CITY OF ALBUQUERQUE

January 31, 2022

Re: Presbyterian Emergency/Urgent Care (PresNow Parking Addition)
6400 Paseo Del Norte Blvd NE
Traffic Circulation Layout
Architect's Stamp 01-03-2022 (D18-D056)

SITE PLAN

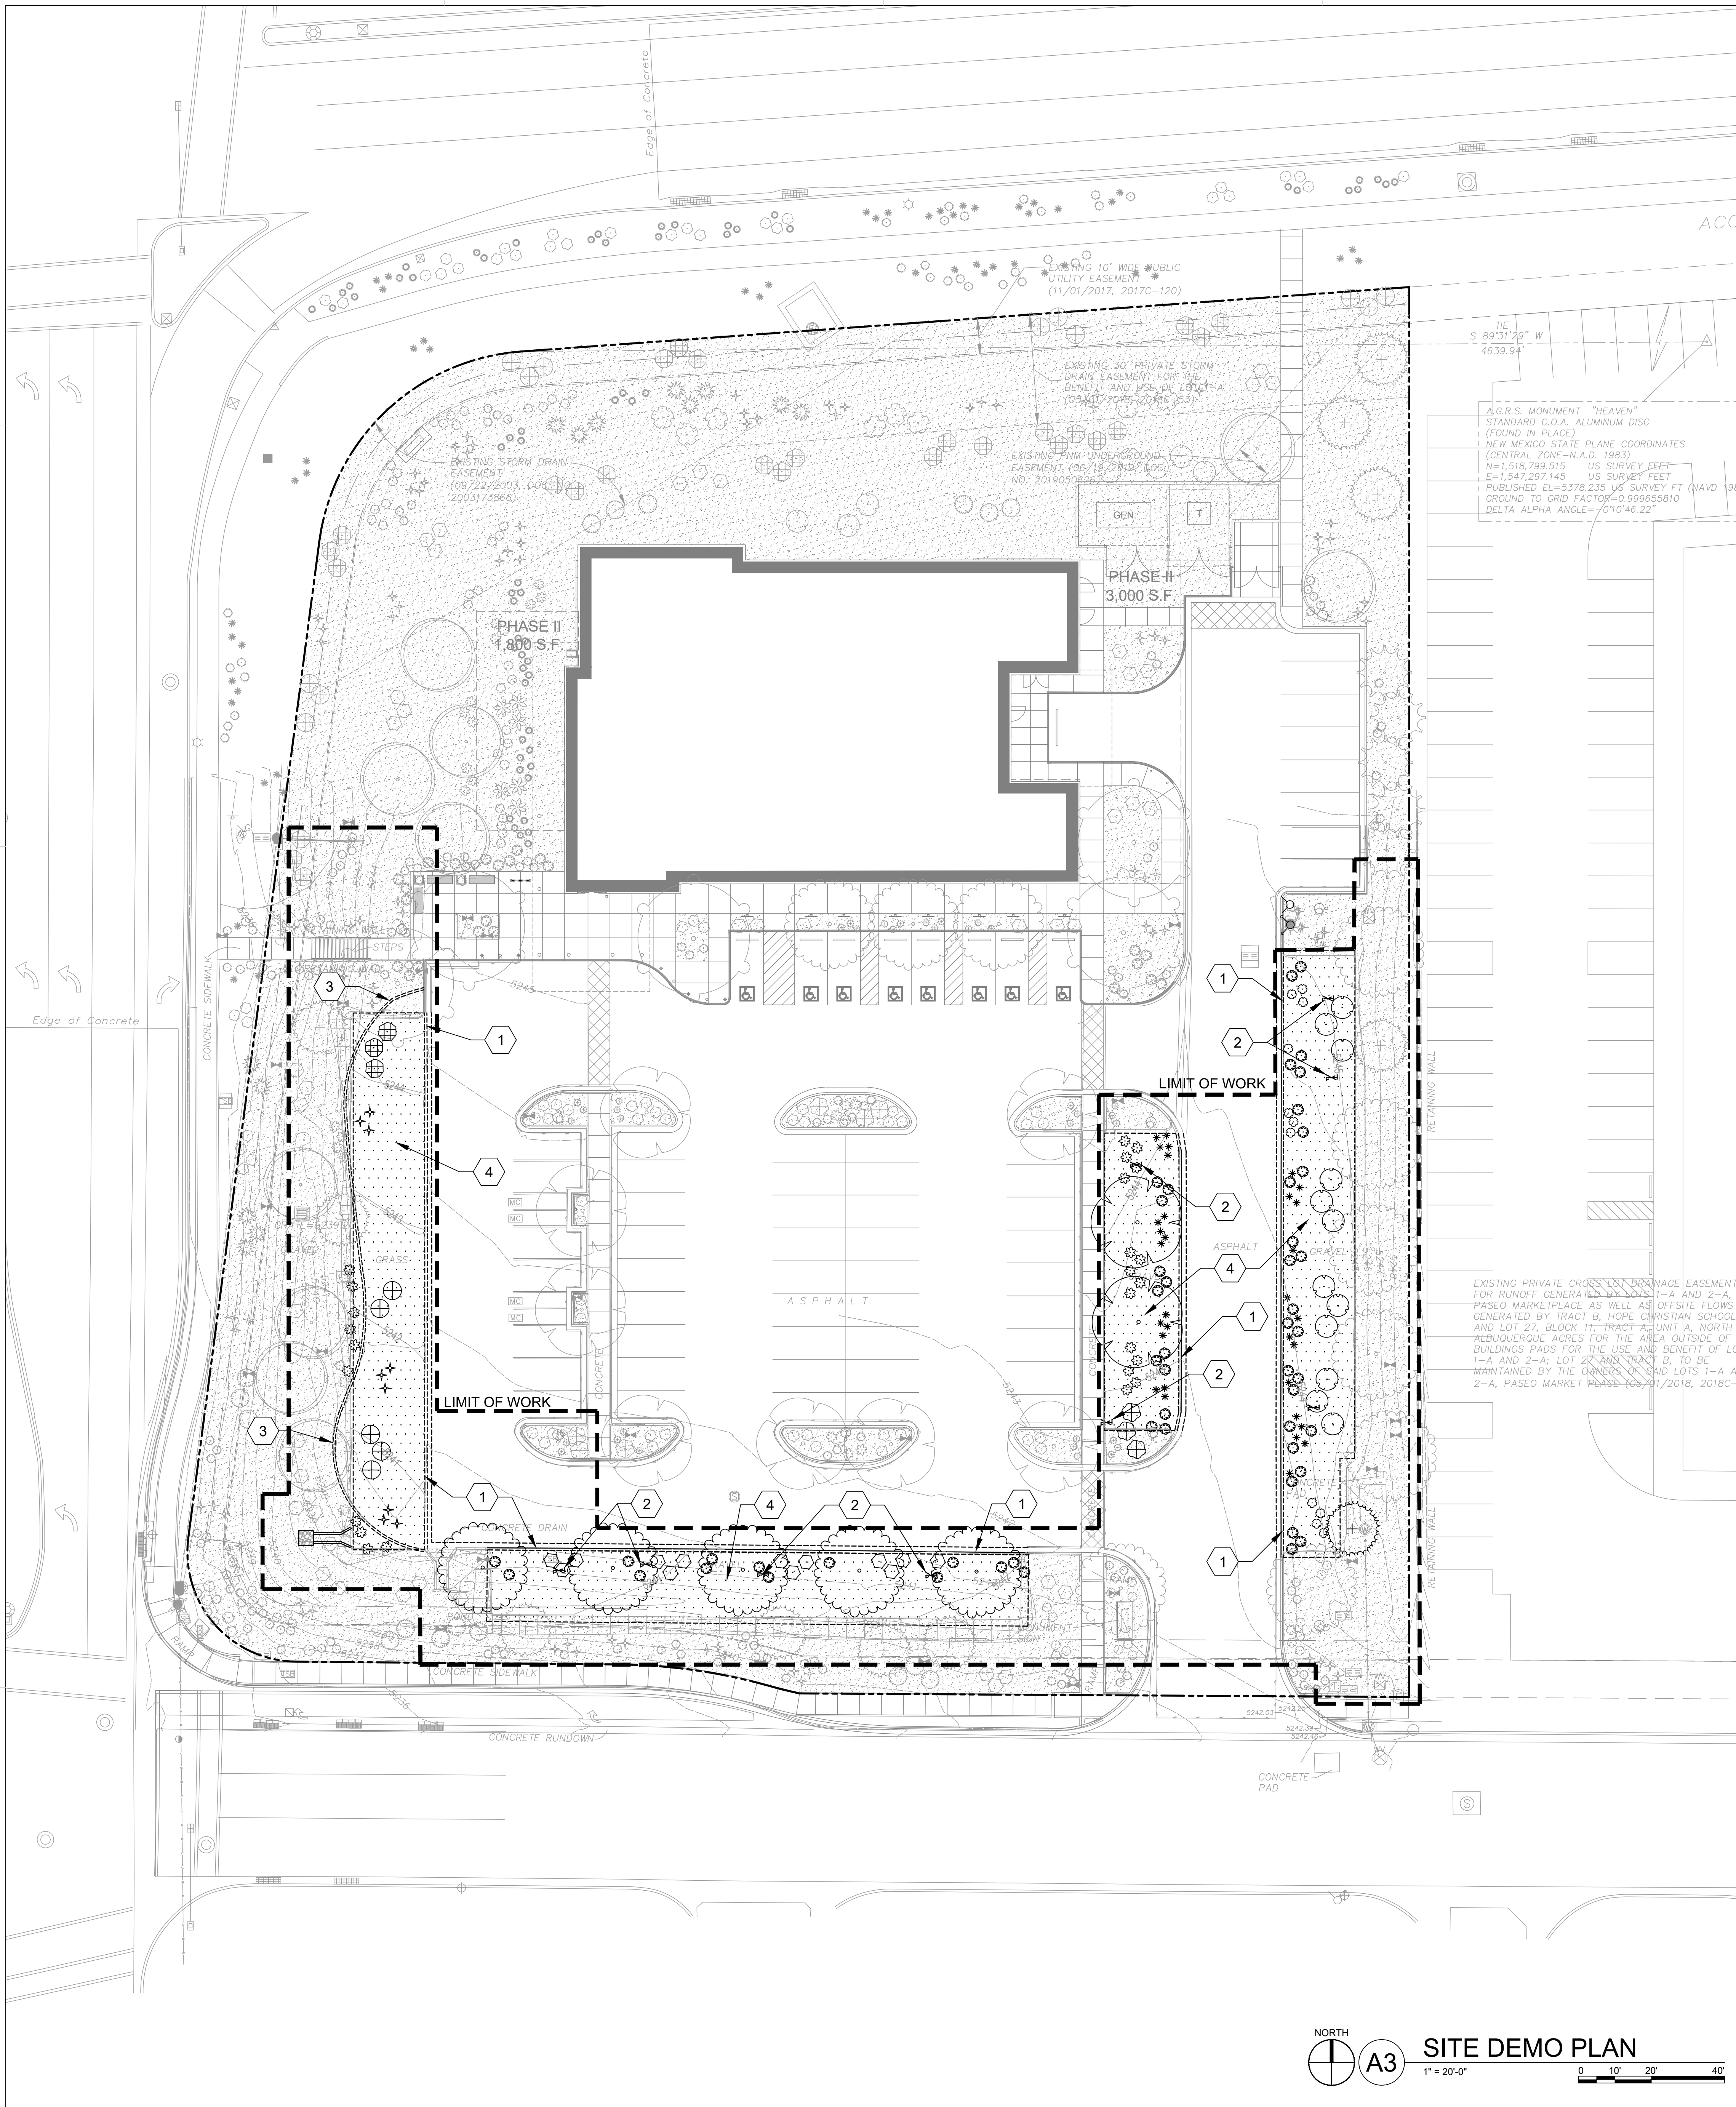
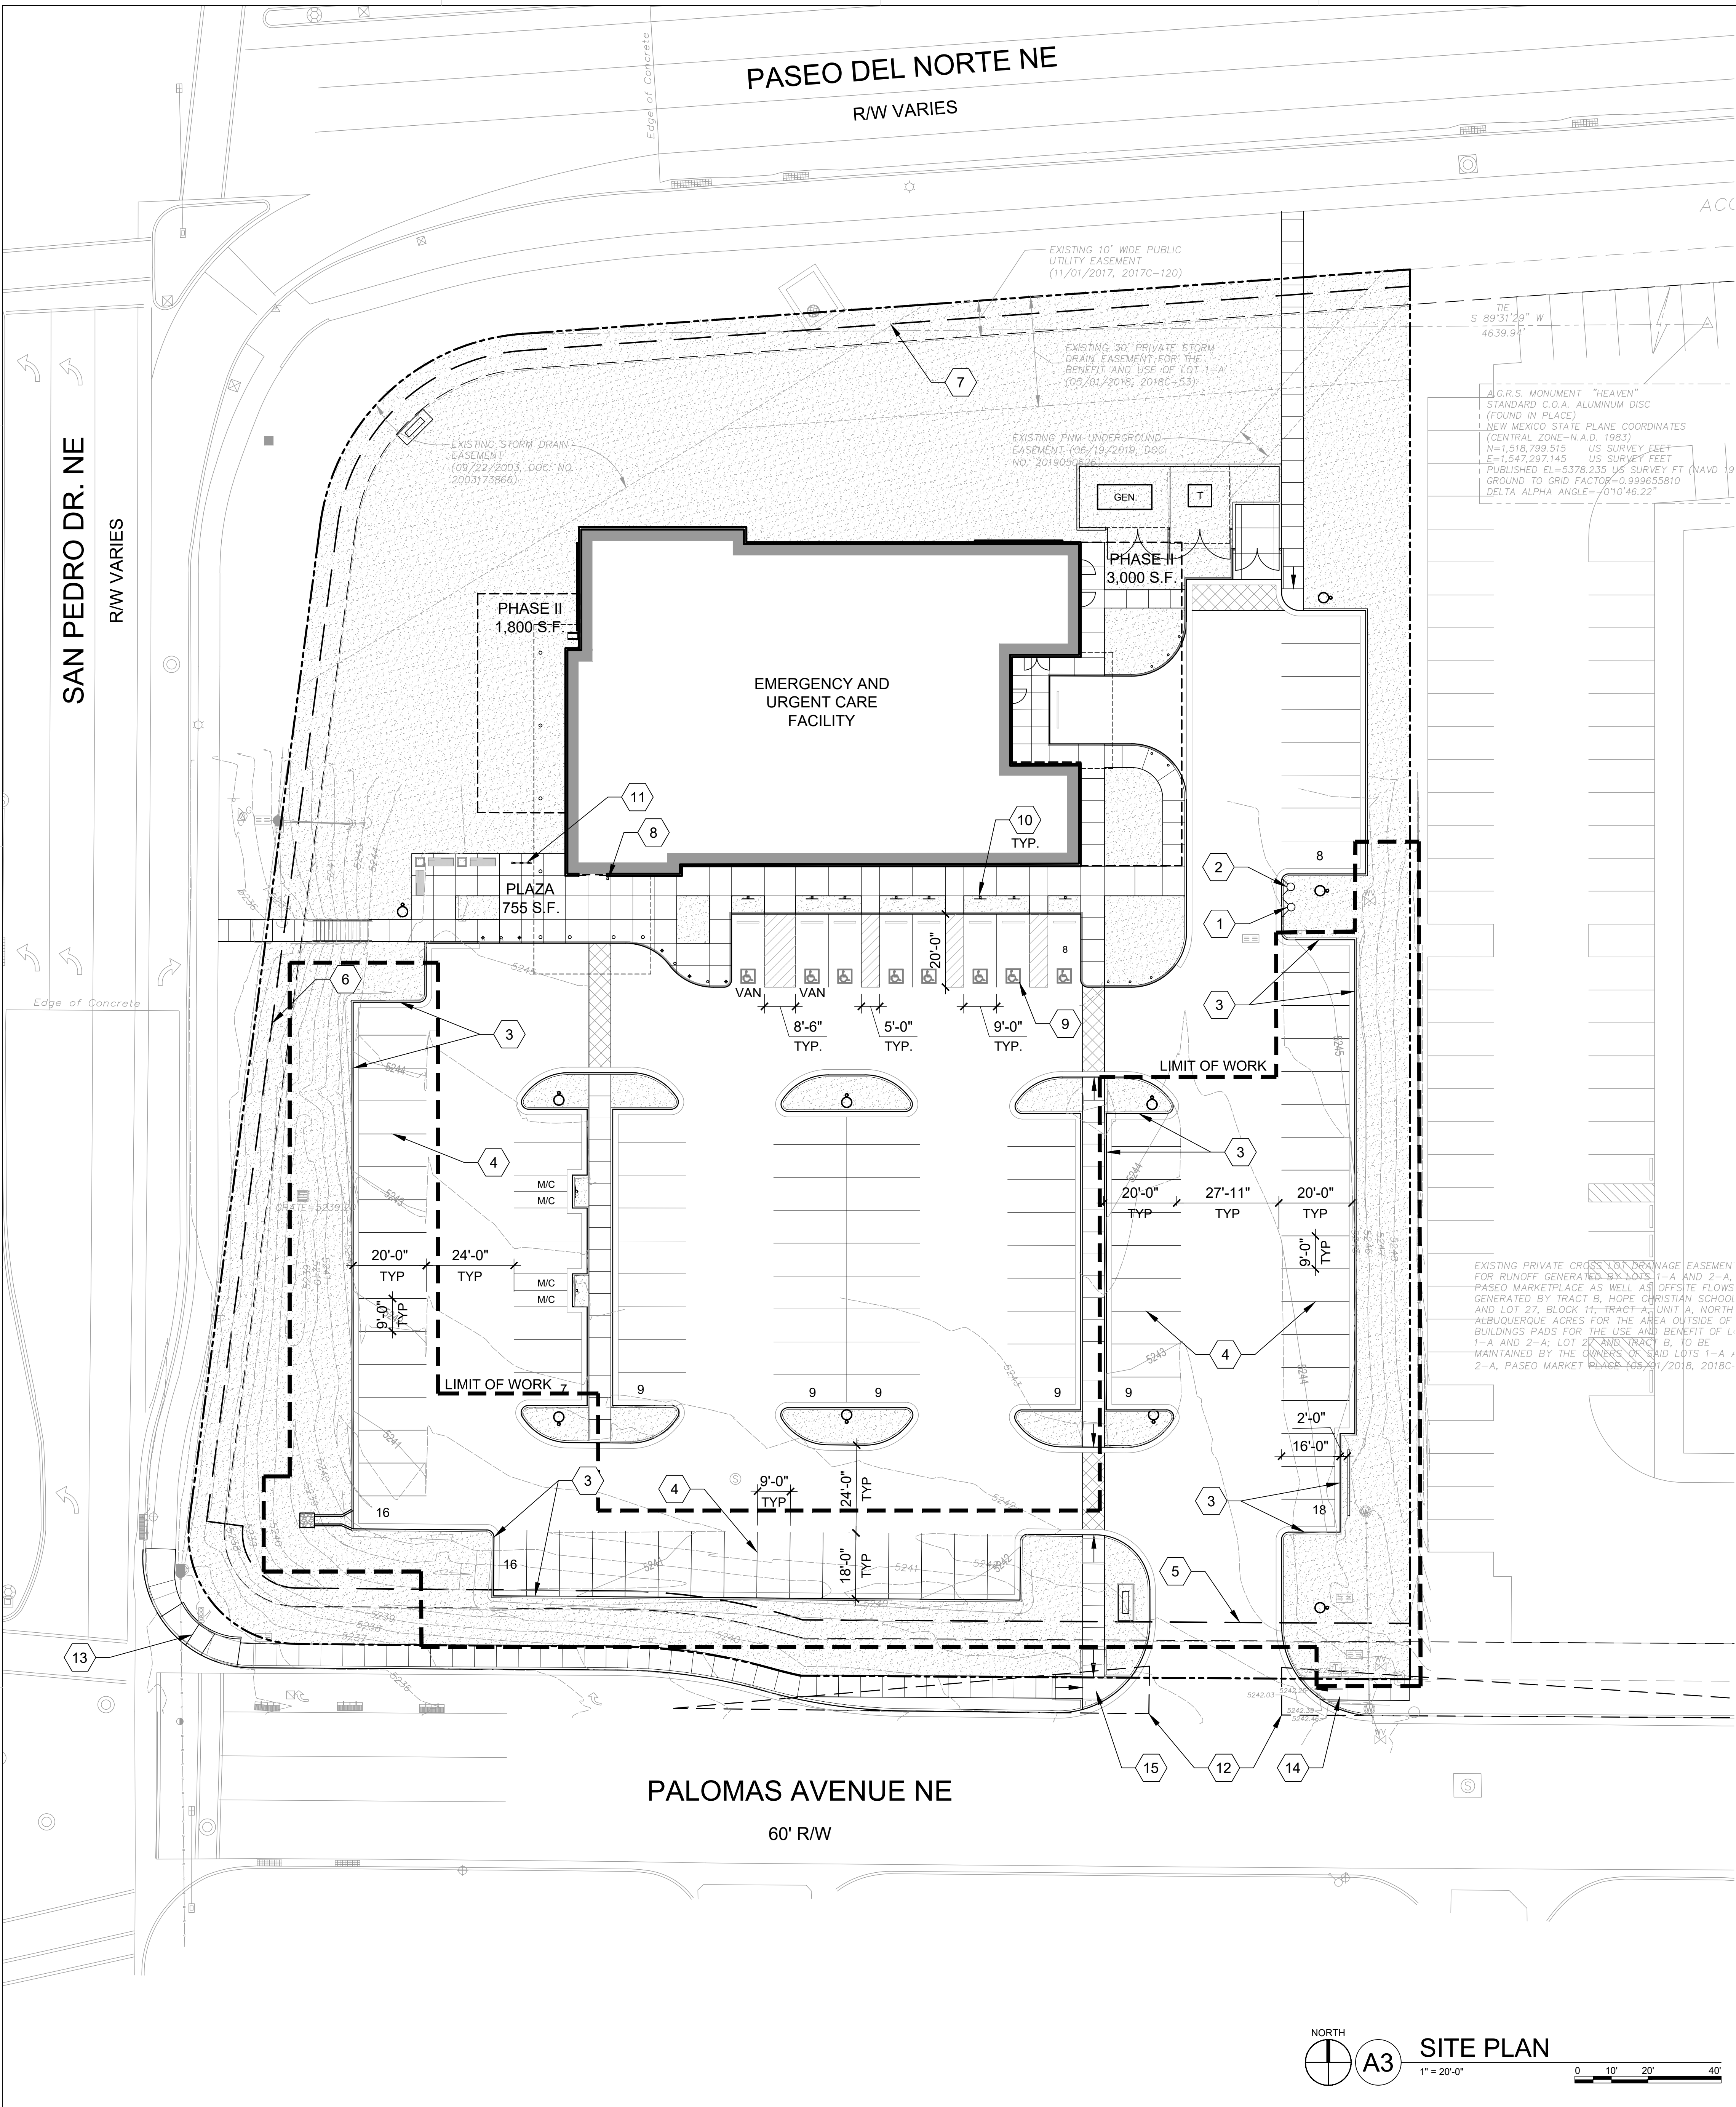
- You show total of one Van Accessible stall but 2 Van Accessible stalls are required. Please address this concern.
2. San Pedro sidewalk connection onto property: You need to verify that the sidewalk connection is 6ft in width for ADA Pedestrian pathway requirements. This is a concern since you have bubbled it and/or verify you have another ADA 6ft wide pedestrian pathway which will service this requirement.

3. The ADA accessible spaces must include an access aisle. Van accessible aisles should be 8ft wide; all others should be 5ft wide.
4. The ADA accessible parking sign must have the required language per 66-7-352.4C NMSA 1978 **"Violators Are Subject to a Fine and/or Towing."** Please call out detail and location of signs.

5. The ADA access aisles shall have the words **"NO PARKING"** in capital letters, each of which shall be at least one foot high and at least two inches wide, placed at the rear of the parking space so as to be close to where an adjacent vehicle's rear tire would be placed. (66-1-4.1.B NMSA 1978)

6. **Palomas Ave. Frontage:**
 - **Both legs:** Existing ADA curb ramps must be updated to current standards and have truncated domes installed. Verify.

- **Western leg existing ramp:** Verify there are not ADA conflicts with on-site sidewalk connection and ramp at junction.
7. All bicycle racks shall be designed according to the following guidelines:

11. Please provide a sight distance exhibit
 12. Show the clear sight triangle and add the following note to the plan: "Landscaping and signage will not interfere with clear sight requirements. Therefore, signs, walls, trees, and shrubbery between 3 and 8 feet tall (as measured from the gutter pan) will not be acceptable in the clear sight triangle.

13. Add a note stating "All broken or cracked sidewalk must be replaced with sidewalk and curb & gutter." A build note must be provided referring to the appropriate City Standard drawing (2430 & 2415A).
